Application No: EP/121/20/HH
Site Address: 49 Manor Road East Preston BN16 1QA
Description of works: First floor extension over existing garage

Thank you for your internet representation made on 10th December 2020 which has been recorded as an objection with the comments as follows:

I am commenting on behalf of the East Preston and Kingston Preservation Society.

PROPOSED ELEVATIONS

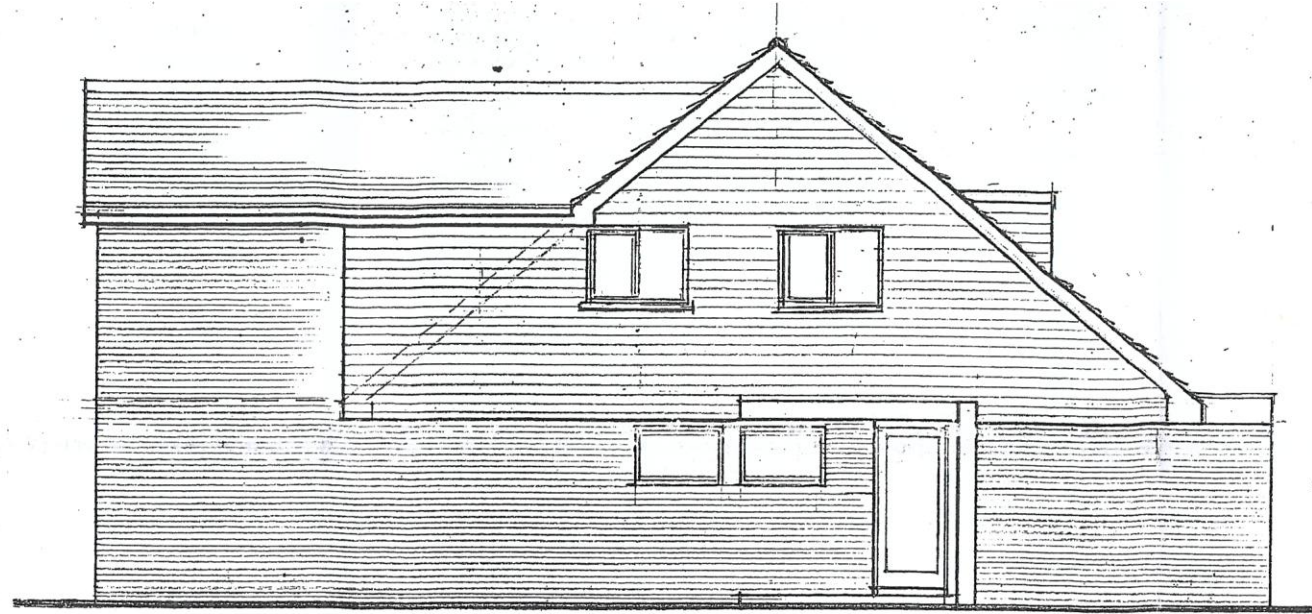
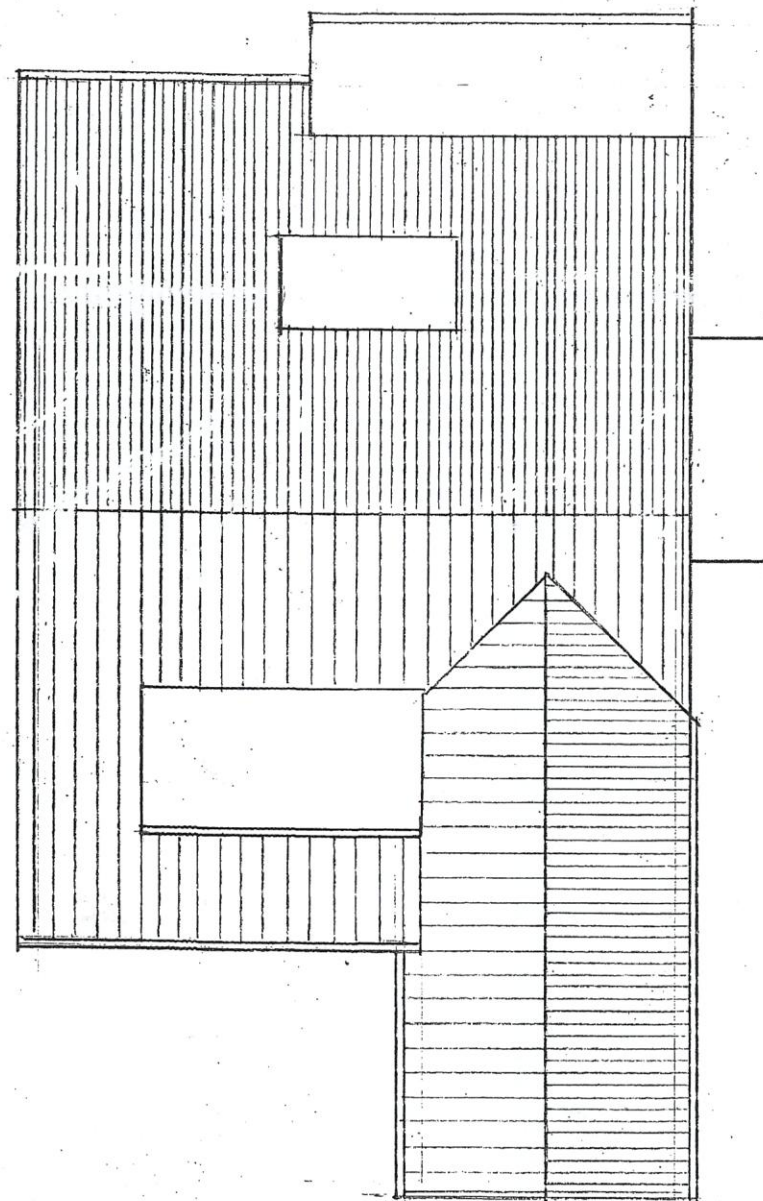
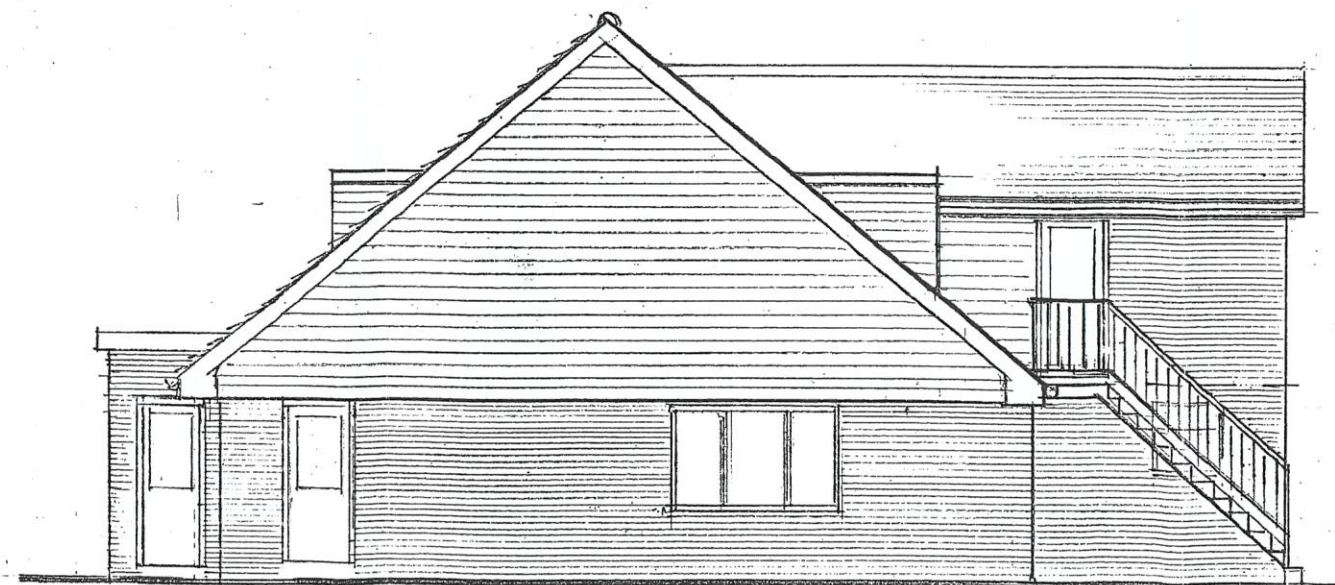
The proposal to convert a single storey garage at the front of this property into a two storey extension, with a pitched roof, would make a significant impact on the street scene and the amenities of neighbouring properties. It would project ahead of the adjoining bungalow (no.51) and create an oppressive and overshadowing impact on the outlook from its front windows. The external staircase that would be added, leading to the new room above the garage, would look an extremely odd feature on the facade of the house, and is wholly inappropriate in this setting.

This application contravenes policy D DM1 of the Local Plan, because it does not reflect or improve upon the character of the site and the surrounding area, and does have an adverse effect on the users and occupiers of nearby properties. It contravenes policy D DM4, because it does have an adverse overshadowing and overbearing effect on neighbouring properties.

The application also contravenes policy 1 of the East Preston Neighbourhood Plan, because the design does not reflect the architectural style of the surrounding buildings. It also fails to follow the Development Principles in paragraph 4.16, which states that extensions should look as if they were part of the original design of the house, and that extensions are best placed at the rear.
